# Gatwick Airport Northern Runway Project

Appendix 8.3.1: Summary of Stakeholder Scoping Responses – Landscape, Townscape and Visual Resources

VERSION: 1.0

DATE: JULY 2023

DRAWING NO. <b>FIGURE 8.4.1</b>	REVISION <b>For ES Issue</b>
	DRAWN BY <b>MS/JP</b>	PM / CHECKED BY <b>PE</b>

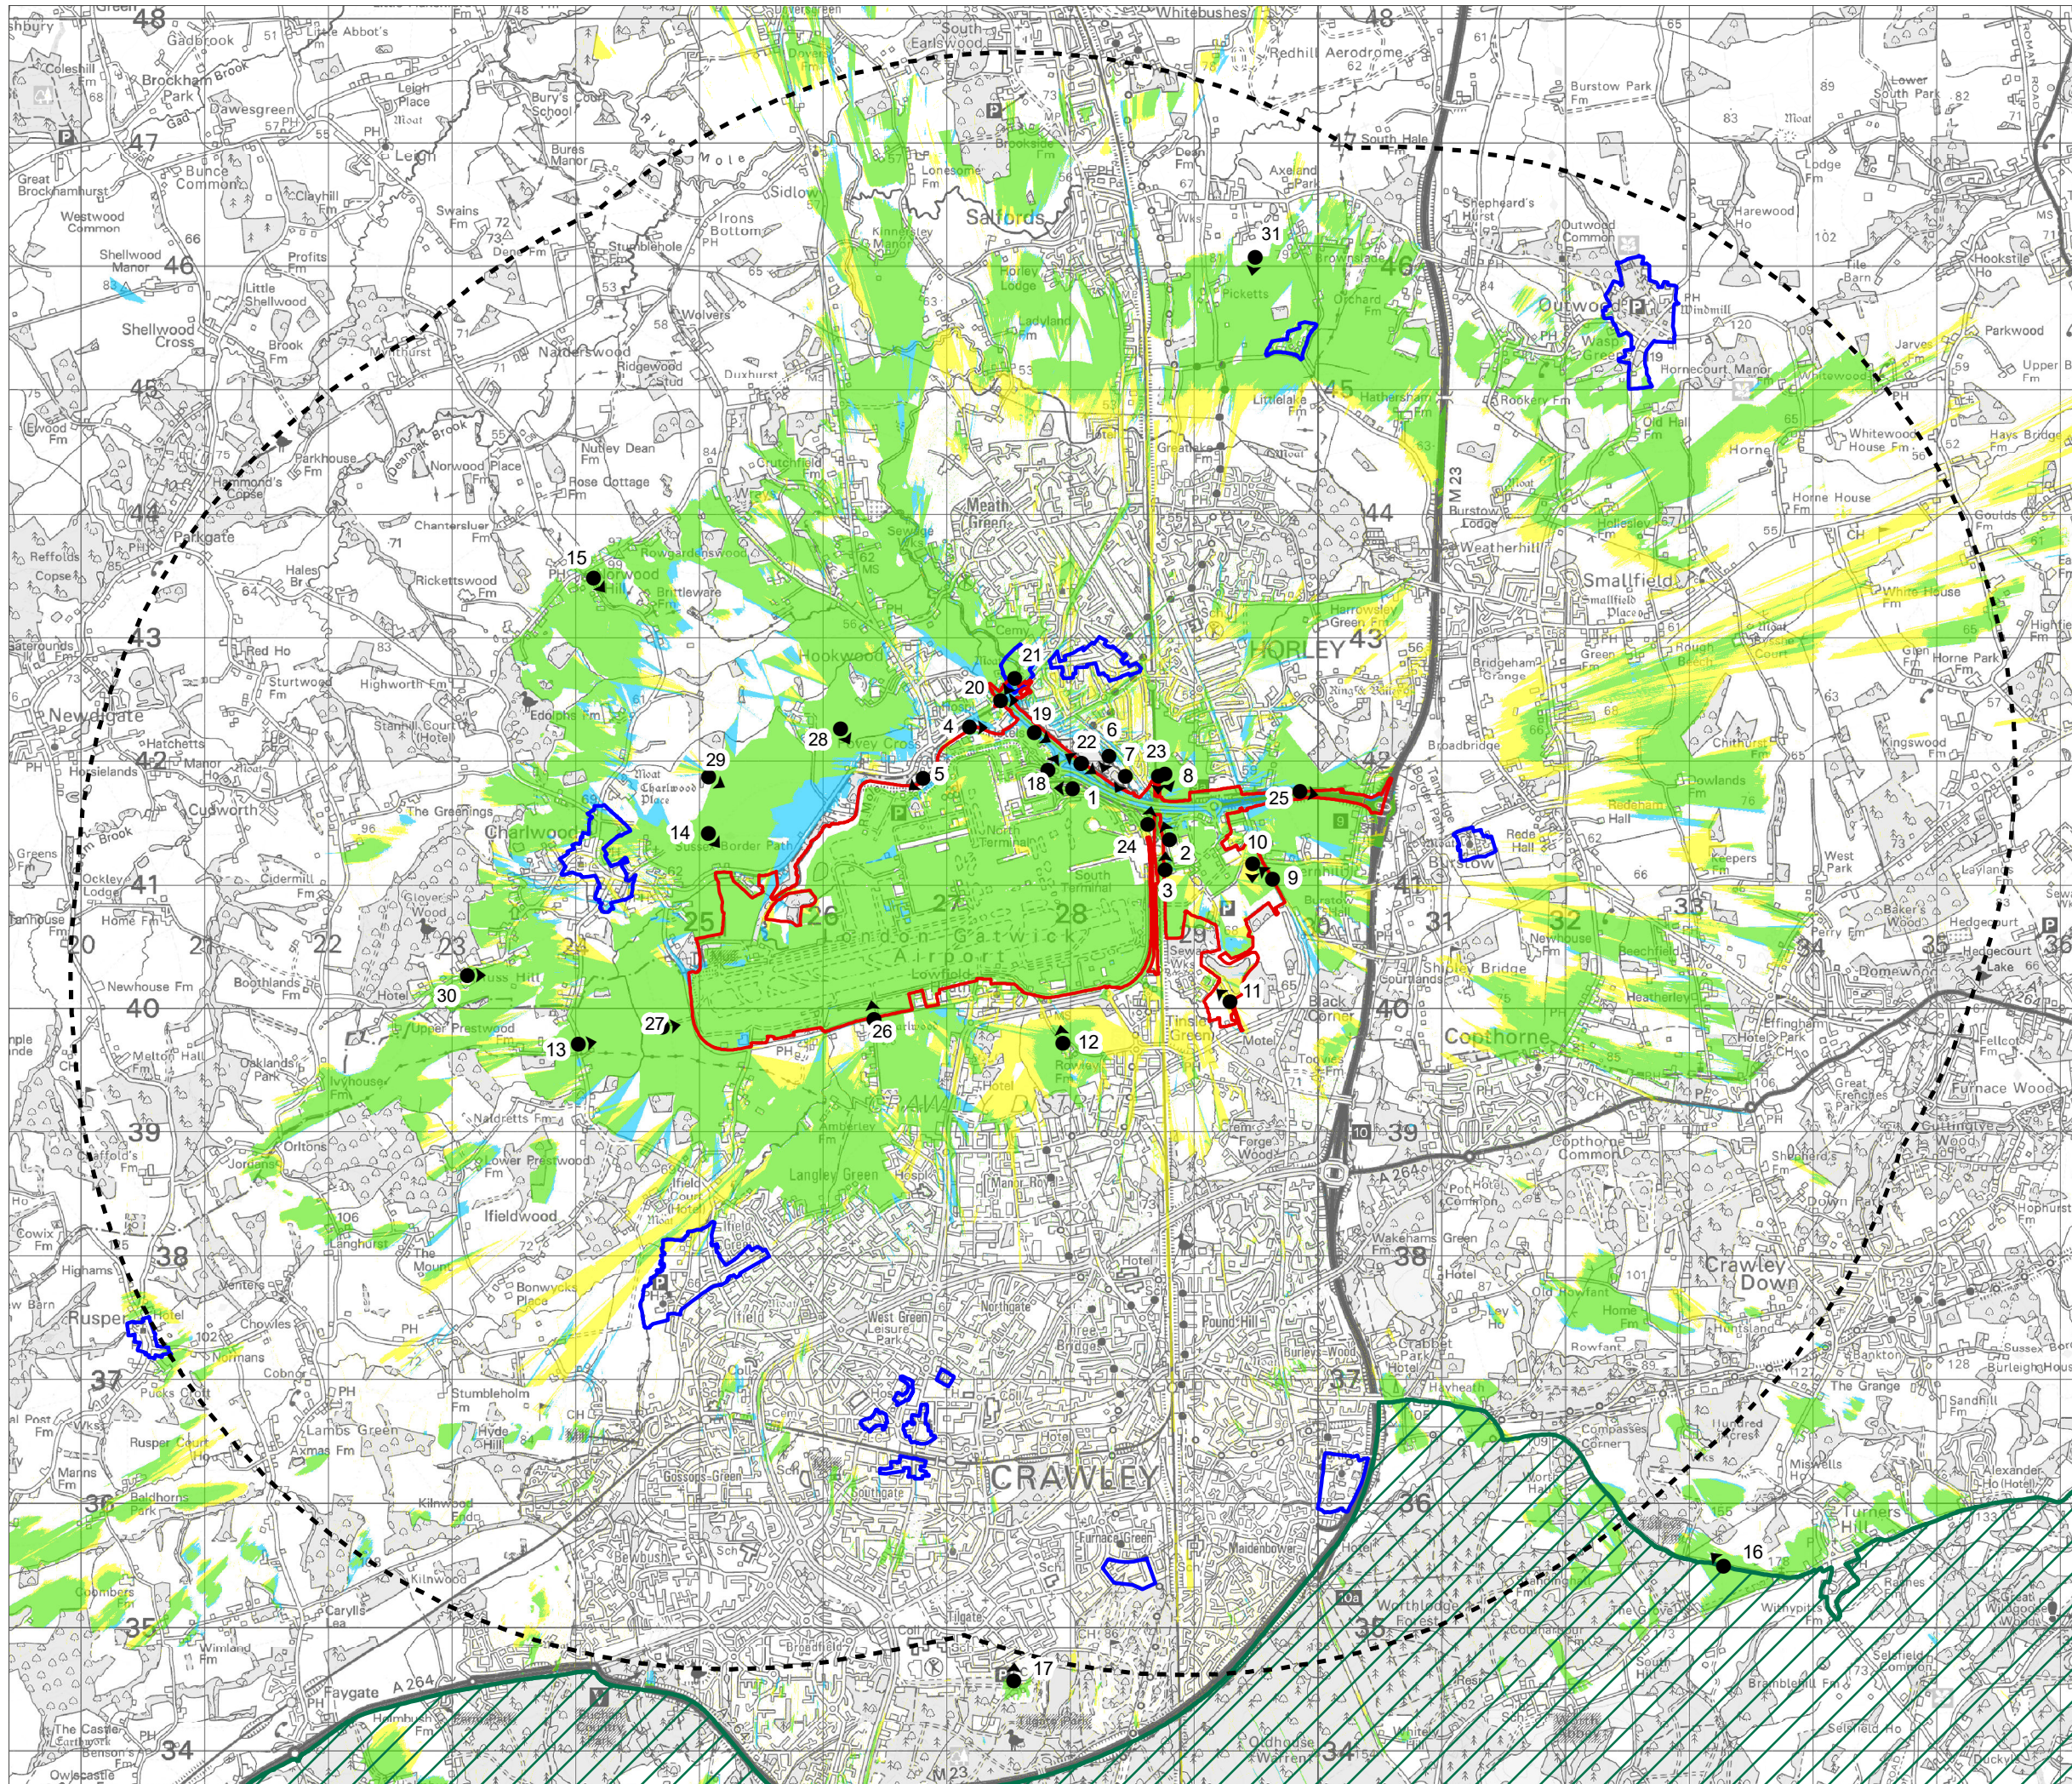
Consultee	Date	Details	How/where taken into account in ES
			potential significant effects on landscape, townscape and visual resources are assessed.
Crawley Borough Council	30 September 2019	CBC consider that the ZTV identified in paragraph 7.2.4 is not extensive enough to capture the key views of the airport from within the Borough Boundary as identified in policy CH8 of the adopted Crawley Borough Local Plan. The study area should be extended to capture the long distance views identified in the policy from Tilgate Park, Junction 11 with A23/A264 and Target Hill.	The preliminary 5 km radius study area has been reviewed. ZTVs have been generated which extend beyond a 15 km radius from the Project site to identify the potential for intervisibility between development at Gatwick, the surrounding landscape and the visual receptors within it (see <b>ES Figure 8.4.2</b> (Doc Ref. 5.2)). The ZTV indicates that the vast majority of land that may be potentially intervisible with development at Gatwick Airport lies within the 5 km radius area. This has defined an appropriate study area to capture the relevant landscape, townscape and visual receptors that are likely to be affected by the Project and to ensure that all likely significant effects have been identified within the <b>ES Chapter 8: Landscape, Townscape and Visual Resources</b> (Doc Ref. 5.1). Site surveys identified that there are no views of Gatwick from the A23/A264 junction, and extremely limited views from Target Hill, and thus it is highly unlikely that significant effects would occur at these locations. Tilgate Park is included as a viewpoint location within the visual assessment in <b>ES Chapter 8</b> .

West Sussex County Council	[Date?]	In reference to Paragraph 7.2.4: We disagree with the use of a zone of theoretical visibility (ZTV) based on the heights of existing buildings, given that the proposed CARE facility would have a stack of up to 50m in height. Table 4.6.1 notes that the maximum height of the South Terminal is 40m, so this would potentially be 10m higher than the tallest feature on site. The final stack height is unlikely to be known until air quality/dispersal modelling has been undertaken as part of the Environment Permitting process. With the CARE facility not being relocated until 2026-2034 (paragraph 5.3.6), for the purposes of the DCO process, and using the Rochdale Envelope, a 50m stack height must be assumed. As a result, consideration in the assessment should be given to the impact of the plume, and lighting on top of the stack. It is also unclear whether the ZTV includes the hotels in the surrounding area.	ZTVs have been generated for both existing and proposed development at Gatwick. The primary 5 km radius study area is considered sufficient to inform the ES. A location for the 48 metre high stack at the CARE facility has been included in the proposed ZTV, together with maximum parameters for all other main buildings and infrastructure, as a worst case scenario to ensure the study area is sufficient to capture all impacts that could give rise to potential significant effects on landscape, townscape and visual resources. The potential for a visible plume at the CARE facility has been assessed as part of the air quality modelling (see <b>ES Chapter 13: Air Quality</b> (Doc Ref. 5.1)). A maximum of 5 hours of visible plume are predicted annually and it is anticipated that there would be no visible plume greater than 20 m in length at any time of year or during any atmospheric conditions. This data has informed the scope of assessment within the LTVIA.

DRAWING NO. <b>FIGURE 8.4.2</b>	REVISION <b>For ES Issue</b>
	DRAWN BY <b>JM</b>	PM / CHECKED BY <b>PE</b>

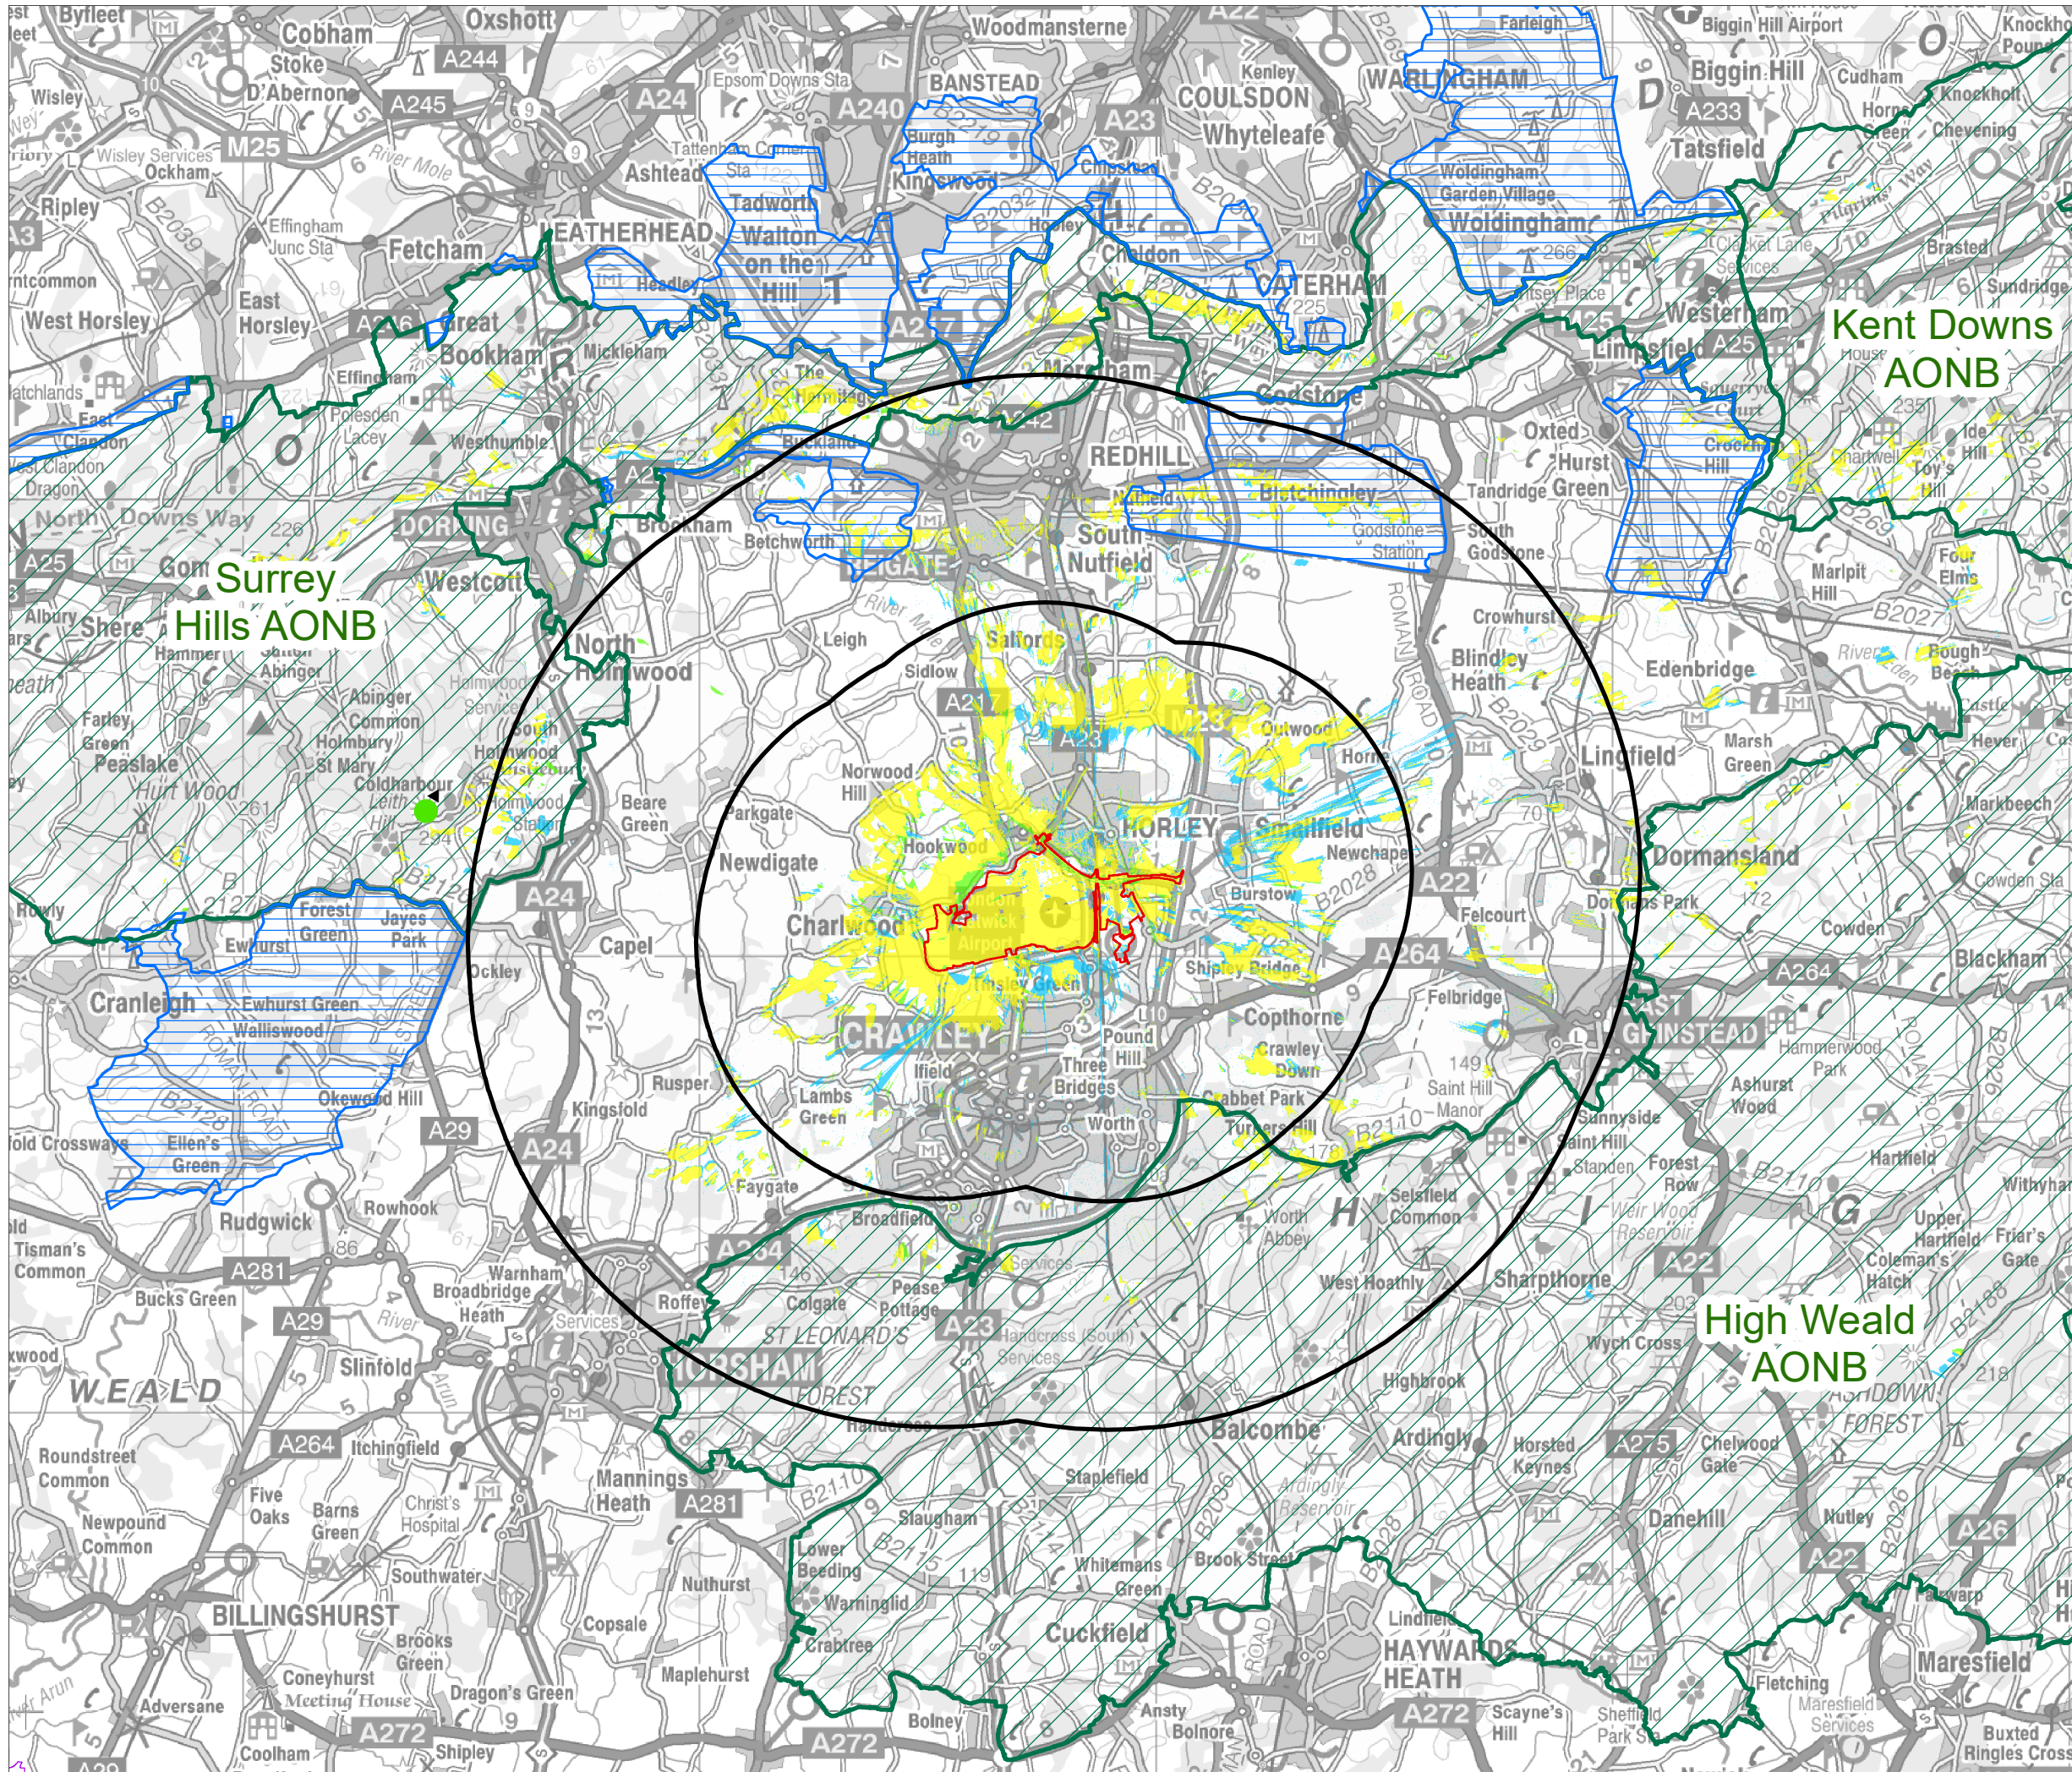
Horsham District Council	27 September 2019	Regarding the proposed study area, it is stated that all visual receptors will be scoped out beyond the 5km radius shown on the Zone of Theoretical Visibility (ZTV) map. Although this, in principle, might be the right approach,	ZTVs have been generated which extend beyond a 15 km radius from the Project site to identify the potential for intervisibility between development at Gatwick, the surrounding landscape and the visual

Mid Sussex District Council	1 October 2019	The spatial scope for the 5 km study area should be clarified, given the 50 m height of the boiler and plumes.	ZTVs have been generated which extend beyond a 15 km radius from the Project site to identify the potential for intervisibility between development at Gatwick, the surrounding landscape and the visual receptors within it (see <b>ES Figure 8.4.2</b> (Doc Ref. 5.2)). The ZTV

Consultee	Date	Details	How/where taken into account in ES
		the plan submitted does not show the areas beyond and it is therefore difficult, at this stage to confirm whether there are any other relevant viewpoints the Council would want to see assessed.	receptors within it (see <b>ES Figure 8.4.2</b> (Doc Ref. 5.2)). The ZTV indicates that the vast majority of land that may be potentially intervisible with development at Gatwick Airport lies within the 5 km radius area. This has defined an appropriate study area to capture the relevant landscape, townscape and visual receptors that are likely to be affected by the Project and to ensure that all likely significant effects have been identified within the ES.
Horsham District Council	27 September 2019	The Council is concerned that the impact of the proposals on the High Weald Area of Outstanding Natural Beauty has not been adequately addressed and would request that any impacts on this protected landscape are given direct consideration as part of the EIA process.	There is a very small overlap between the ZTV and the High Weald AONB indicating very limited intervisibility with Gatwick Airport or the Project (see <b>ES Figure 8.4.1</b> (Doc Ref. 5.2)). The majority of the High Weald AONB is included within the wider study area for the assessment of change in the perception of tranquillity as a result of overflying aircraft. Viewpoints assessed within <b>ES Chapter 8: Landscape, Townscape and Visual Resources</b> (Doc Ref. 5.1) include Turner's Hill within the High Weald AONB, just outside the 5 km radius study area. (see Visual Resources in Section 8.6 of <b>ES Chapter 8</b> ). Effects on the relevant special qualities of the High Weald AONB and the character areas within it are considered throughout <b>ES Chapter 8</b> .

Consultee	Date	Details	How/where taken into account in ES
			indicates that the vast majority of land that may be potentially intervisible with development at Gatwick Airport lies within the 5 km radius area. This has defined an appropriate study area to capture the relevant landscape, townscape and visual receptors that are likely to be affected by the Project and to ensure that all likely significant effects have been identified within the ES. The potential for a visible plume at the CARE facility has been assessed as part of the air quality modelling (see <b>ES Chapter 13: Air Quality</b> (Doc Ref. 5.1)). A maximum of 5 hours of visible plume are predicted annually and it is anticipated that there would be no visible plume greater than 20 metres in length at any time of year or during any atmospheric conditions. This data has informed the scope of assessment within the LTVIA.
Mid Sussex District Council	1 October 2019	The spatial scope for the 'separate' study area' related to over flying aircraft should have regard to frequency and alignment, rather than just height of aircraft	Baseline data for numbers and flight paths of Air Traffic Movements (ATM), and projected numbers of overflying aircraft, have been captured within <b>ES Chapter 14: Noise and Vibration</b> (Doc Ref. 5.1) and have informed the assessment of effects on the perception of tranquillity within <b>ES Chapter 8: Landscape, Townscape and Visual Resources</b> (Doc Ref. 5.1). See also <b>ES Chapter 20: Cumulative Effects and Inter-relationships</b> (Doc Ref. 5.1).
